**Consultation Response from KC,  
Trees**

**2023/91173 749, New Hey Road, Outlane, Huddersfield, HD3 3YL**

**Conversion and extension of existing Listed barn to form one dwelling, alterations to existing farmhouse with associated car parking and external works [Listed Building].**

**Date Responded:13/6/23**

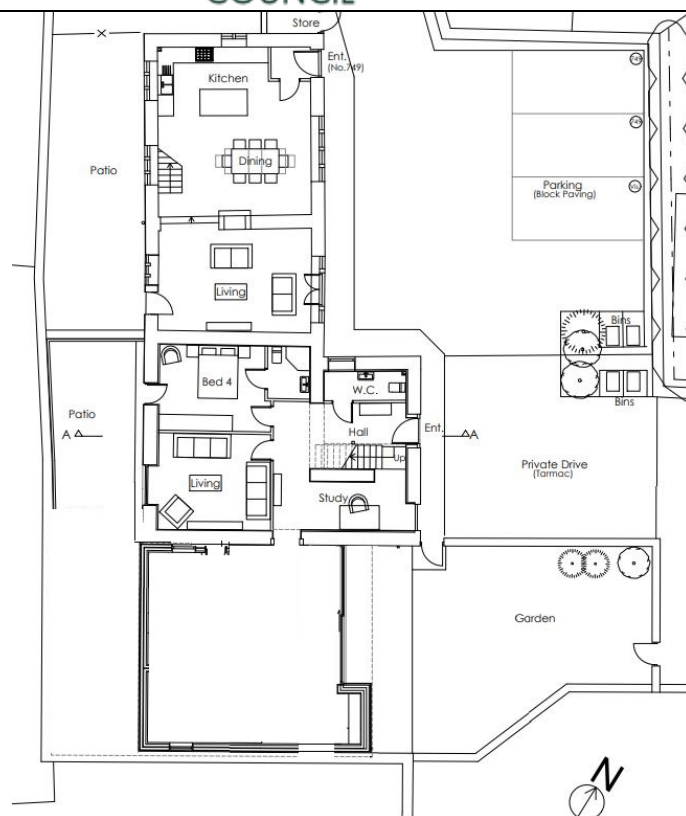
Firstly, we need to know if there is a conflict that is going to be caused to adjacent trees during the work to refurbish the barn and roof? And secondly, about the suitability of the proposed patio areas being constructed underneath the canopy of mature trees located to the south of the site, which will undoubtedly lead to future conflict and desire for tree pruning/removal.

This application needs to be supported by tree information produced in accordance with BS5837, as per our validation checklist and guidance.
